From: Sarah Burrow <Sarah.Burrow@arun.gov.uk>
Sent: 19 October 2021 08:08
To: Planning.Responses <Planning.Responses@arun.gov.uk>
Cc: Simon Davis <Simon.Davis@arun.gov.uk>
Subject: RE: Planning Consultation on: WA/91/21/DOC

Engineers Comments Regarding Surface Water Drainage

Application No: WA/91/21/DOC

Site Address: Land Adjacent 1 Orchard Way Fontwell Arundel BN18 0SH

Soakaway test results

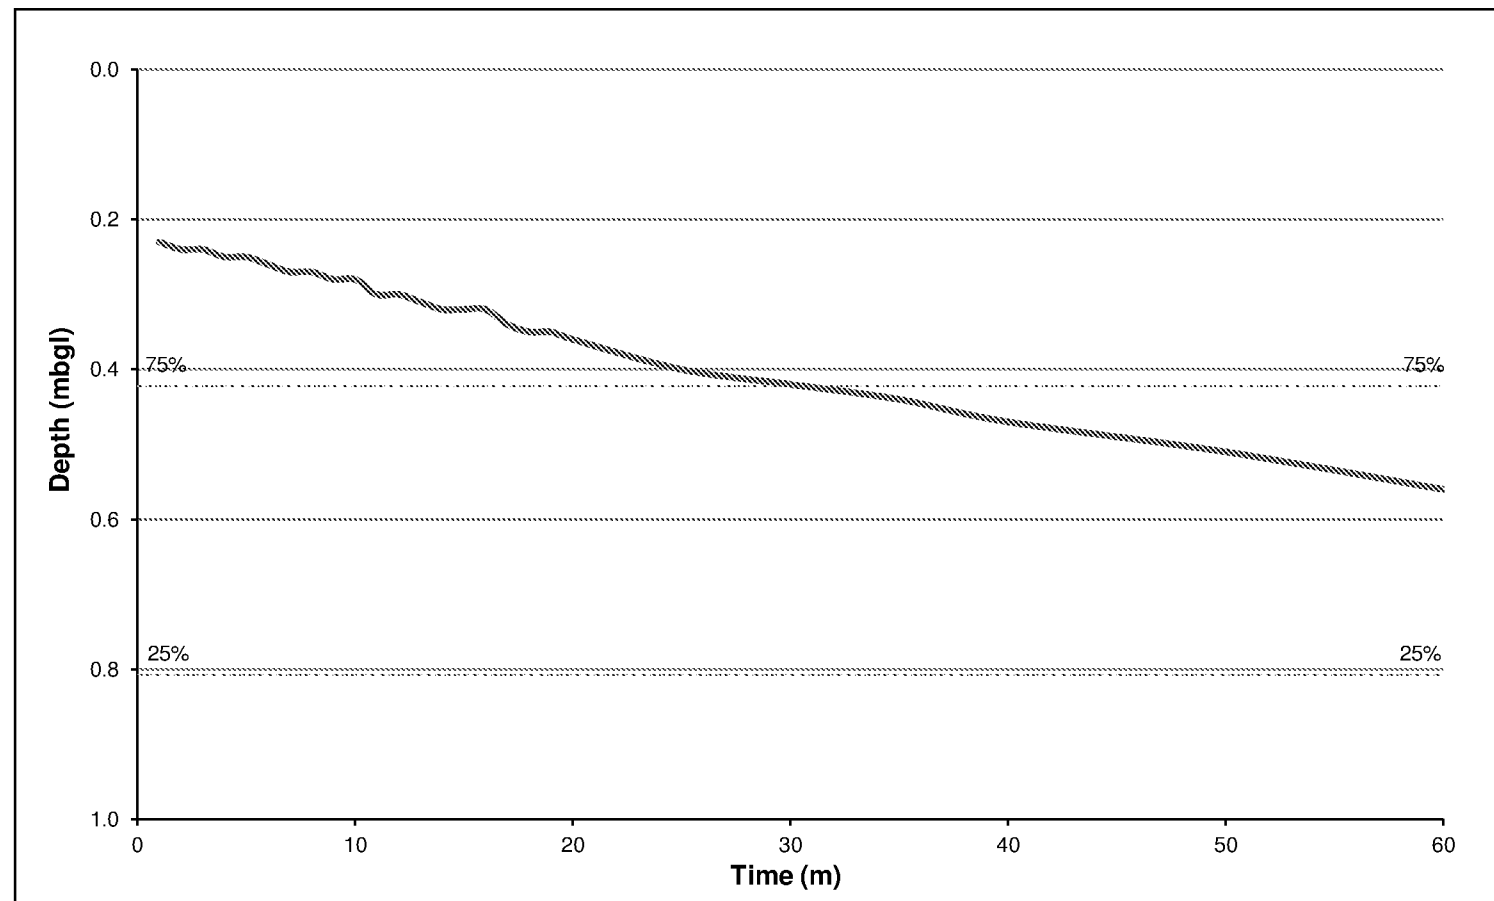
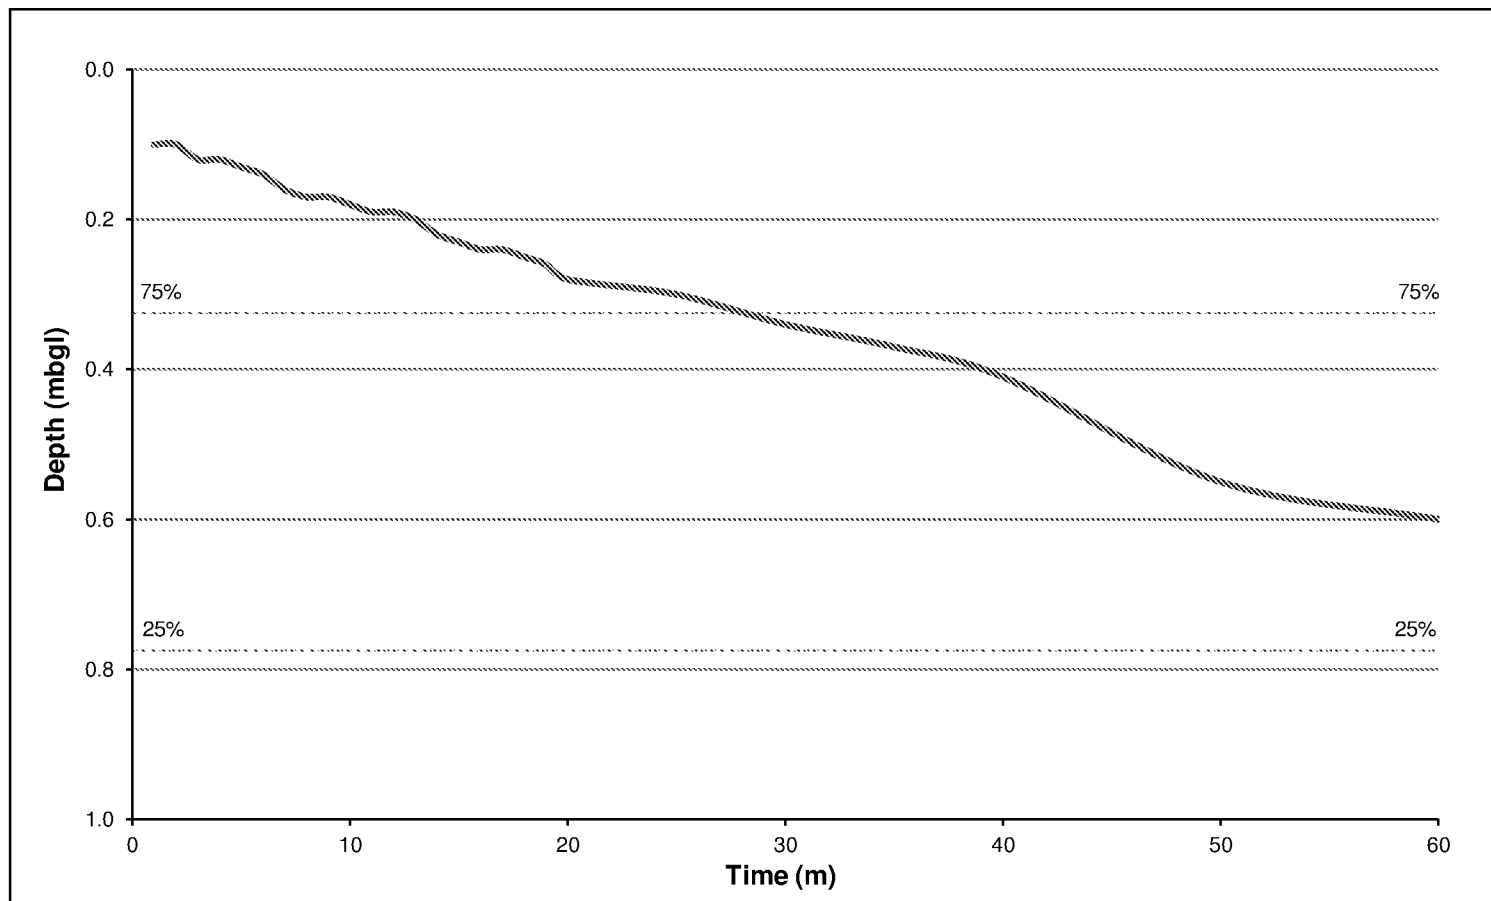
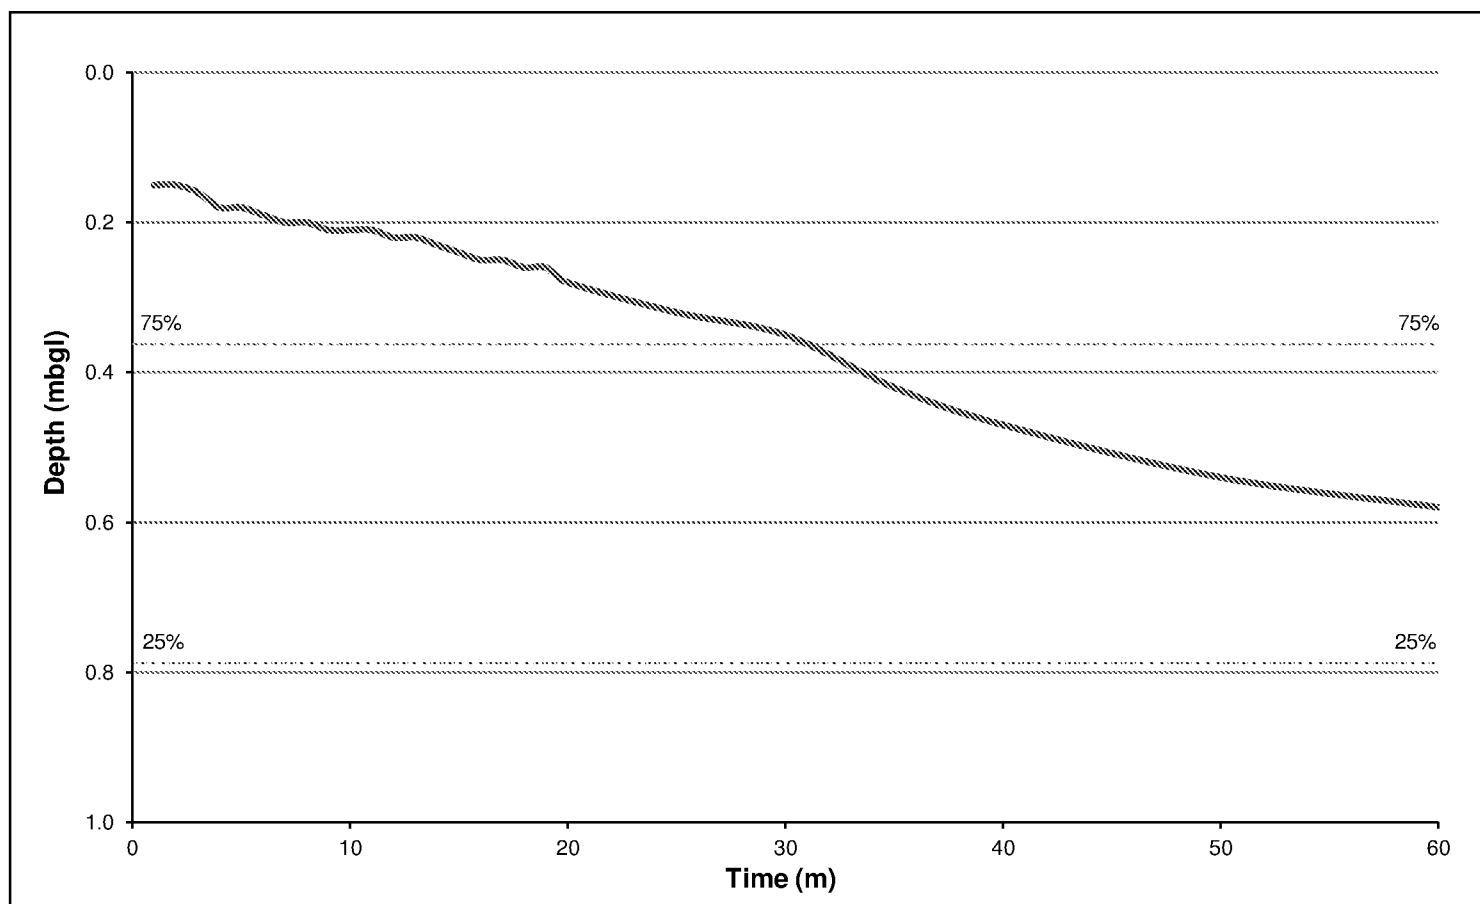
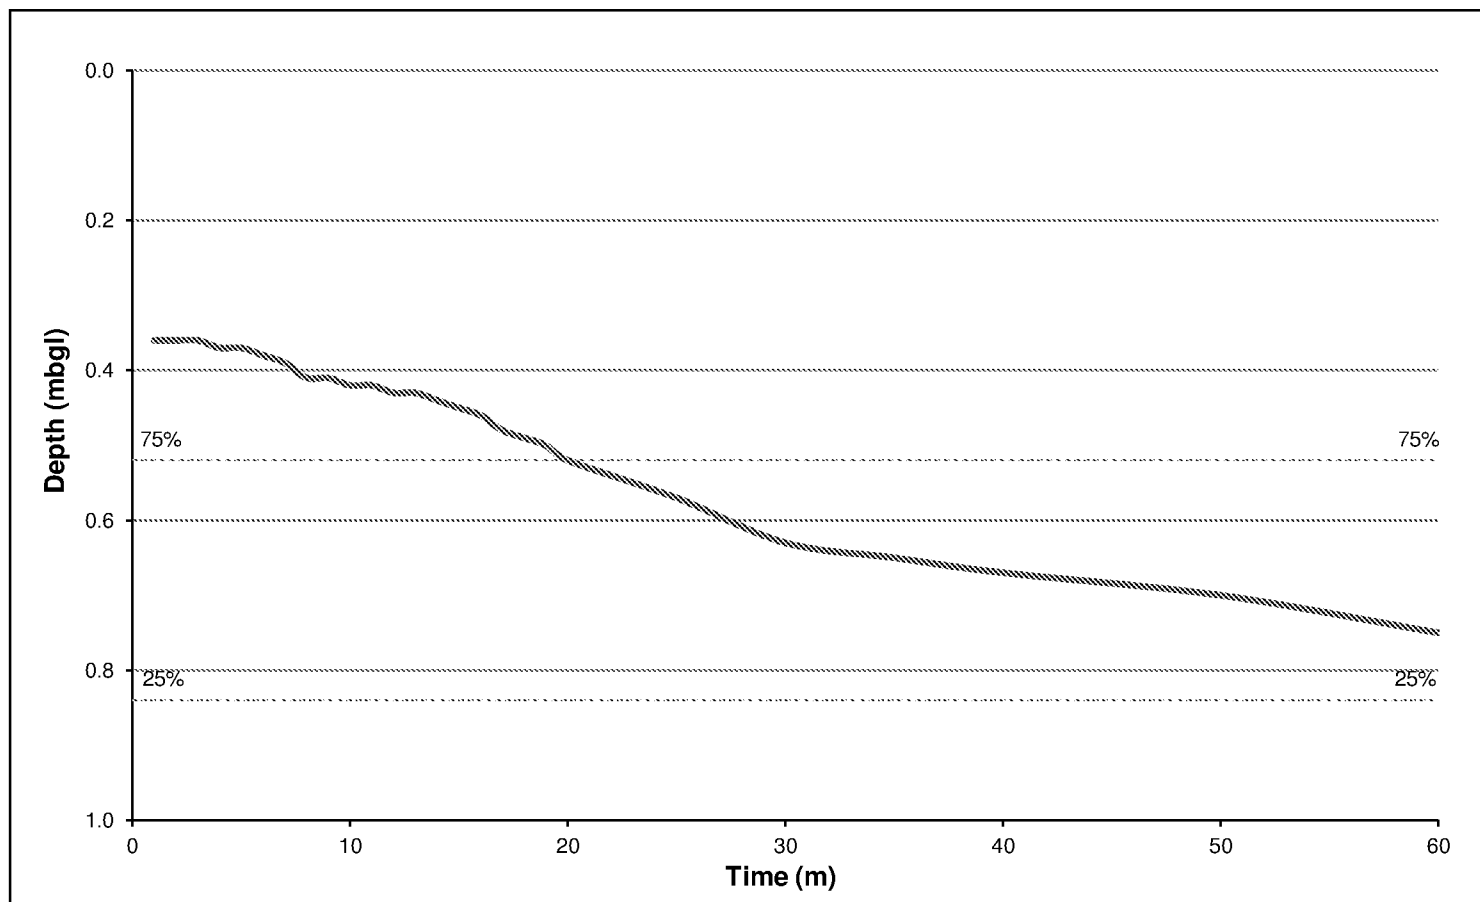
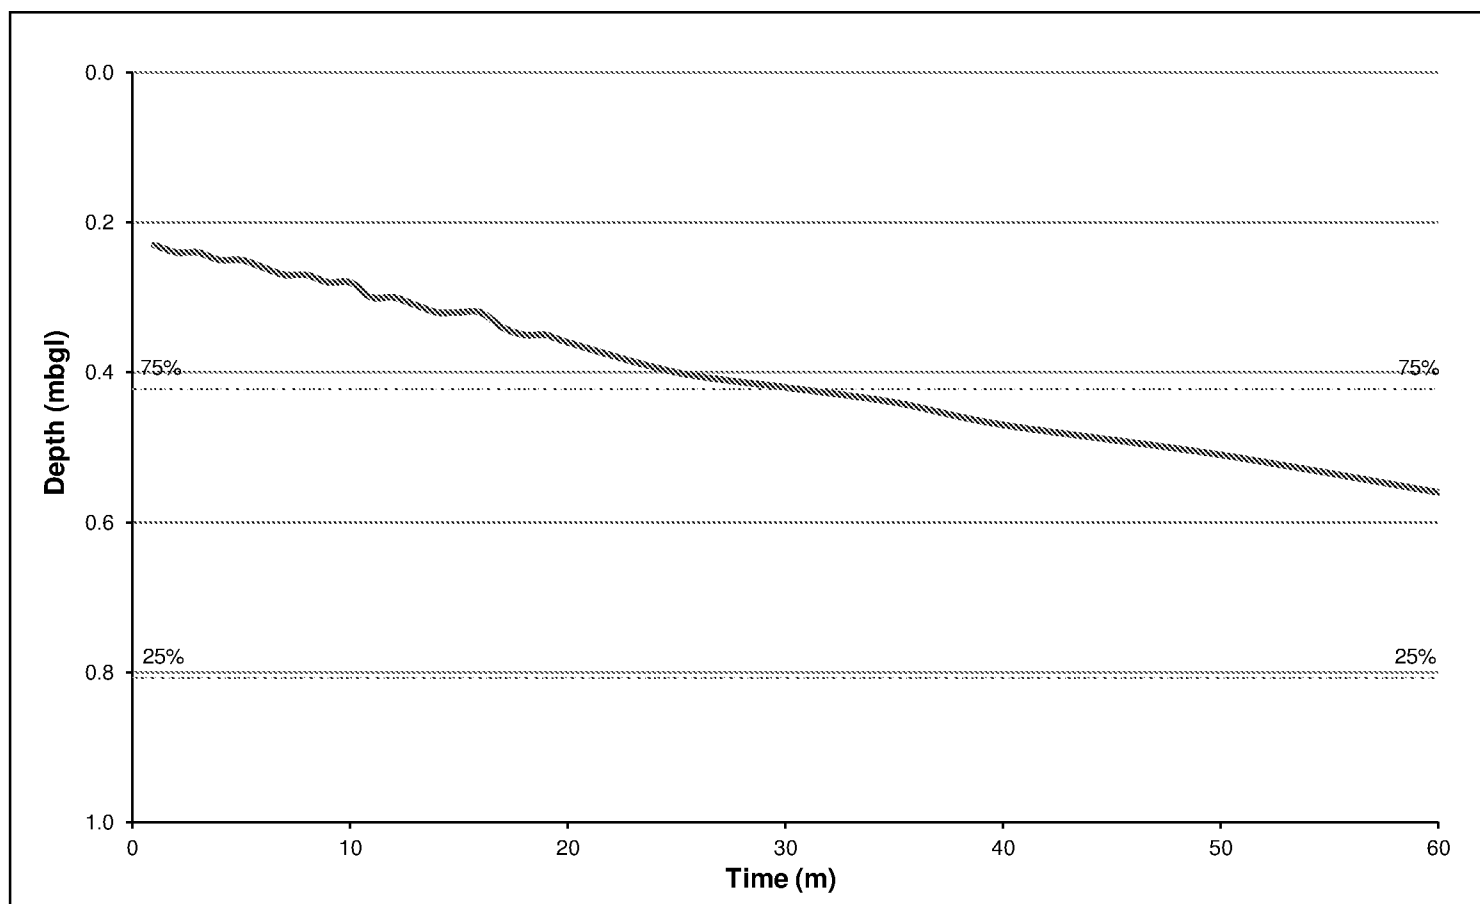
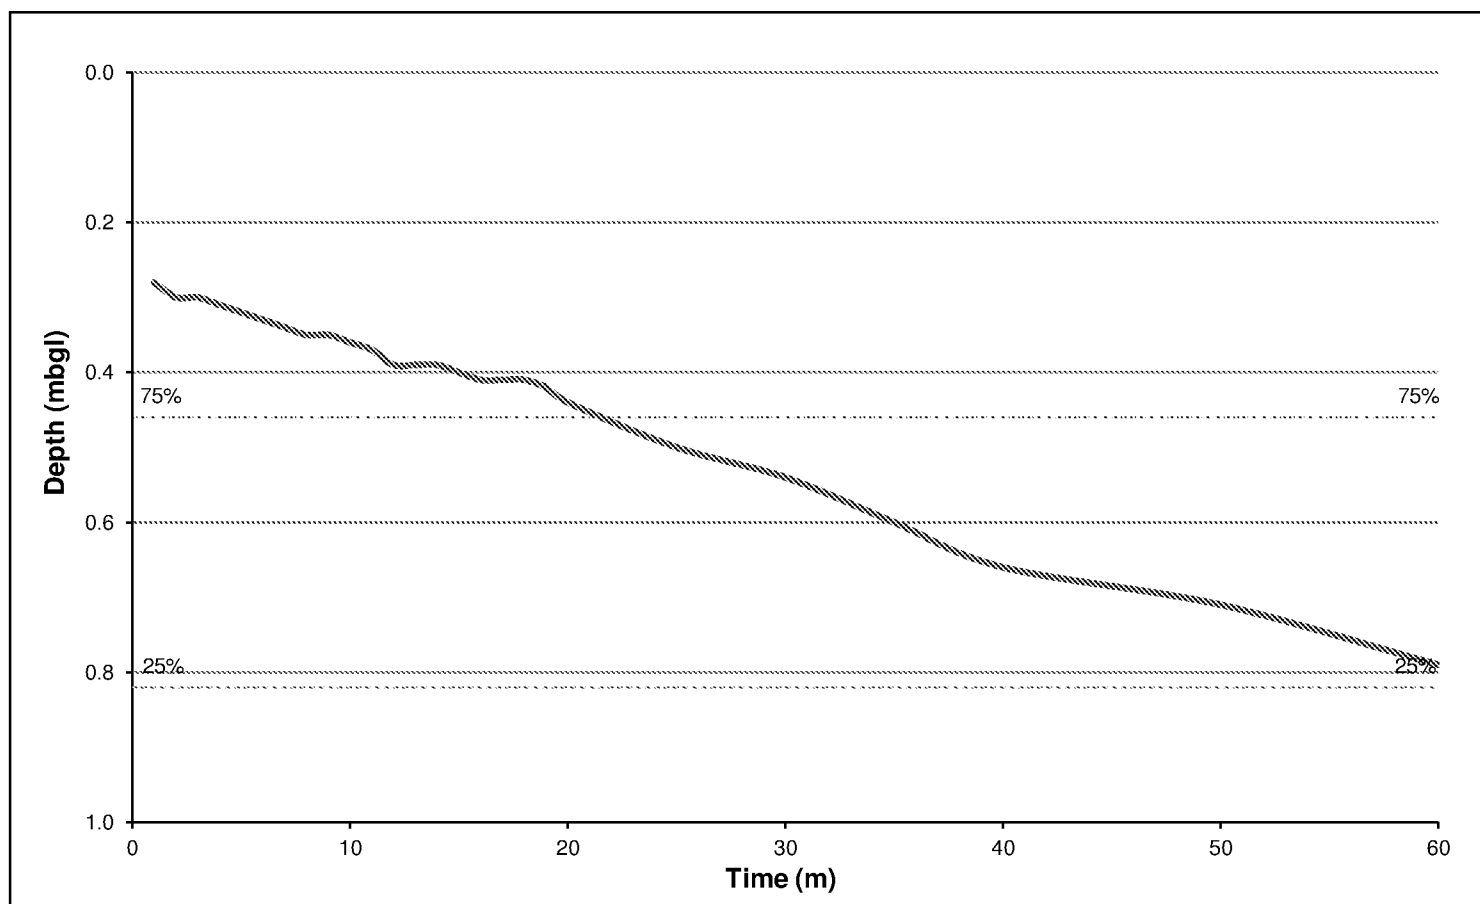
1. Please provide a clear list/table of exactly when and to what depth groundwater was observed.
2. Infiltration testing was only monitored for 60mins for each test after which point the results of almost every test was extrapolated. This is not in strict accordance with BRE DG 365 and no justification is given for the short duration of monitoring. I would like a justification for the methodology and expect a higher factor of safety (of at least 3) to be used in the calculations if these rates are to be used.
